## Appendix 5.1

Scoping Responses

**Re: Diversion Reference DIV24312 Diversion enquiry. Subject to contract | Contract denied**

Uisce Éireann has reviewed your enquiry in relation to a build-over of Uisce Éireann's water main as part of the proposed Development at the townland of Cloonbar, Co Galway as indicated on drawings no. 051021-DR-314 Watermain Over Crossings (DC), 051021-DR-315 Watermain Under Crossings (DC) and Shancloon Location plan.

Typical Double Circuit Watermain Over Crossing Detail

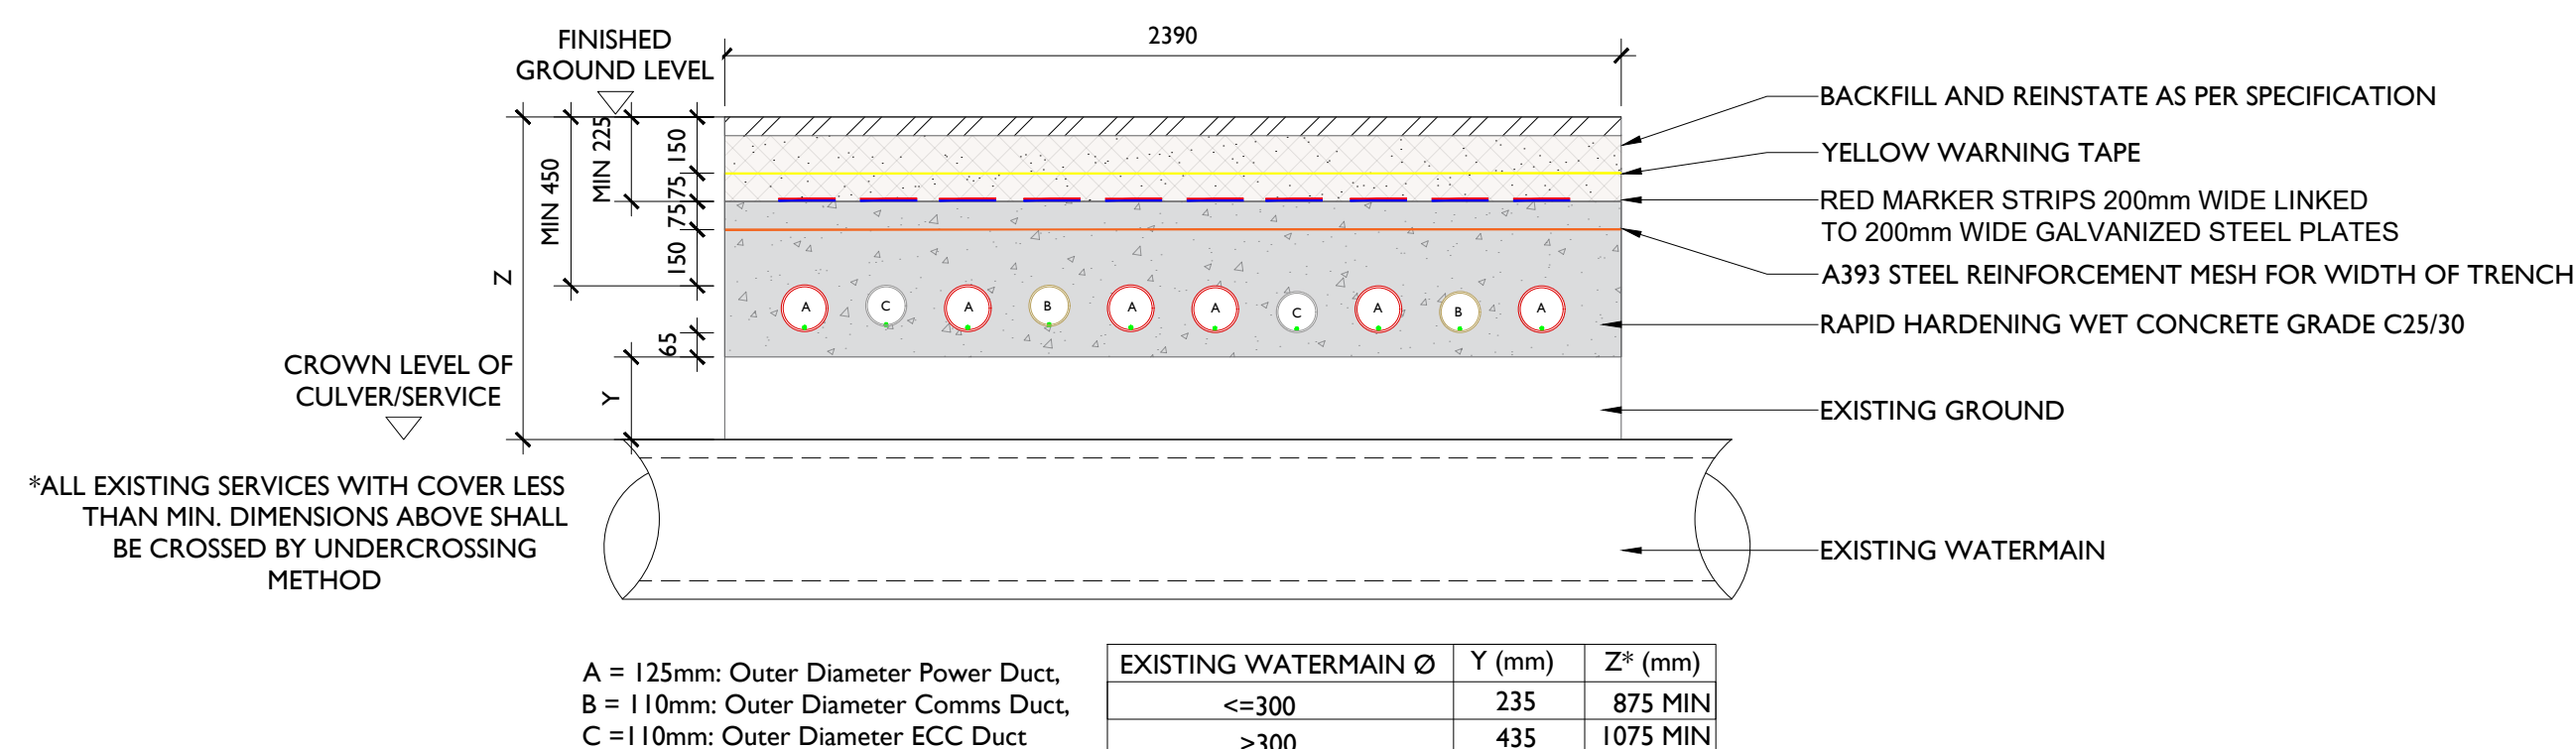
1. Uisce Éireann must be provided with a detailed method statement and risk assessment for working in the vicinity of Uisce Éireann assets as part of the build-over or near agreement process.
2. RWE Renewables Ireland Limited will submit project specific drawings as part of the Build over/ near Agreement application following grant of planning permission and completion of site investigations and detailed design. The specific clearance requirements will be agreed with Uisce Éireann during this process and 500 mm vertical separation provided if deemed necessary.
3. Uisce Éireann will require all crossings of the existing water main to be constructed below the pipe.
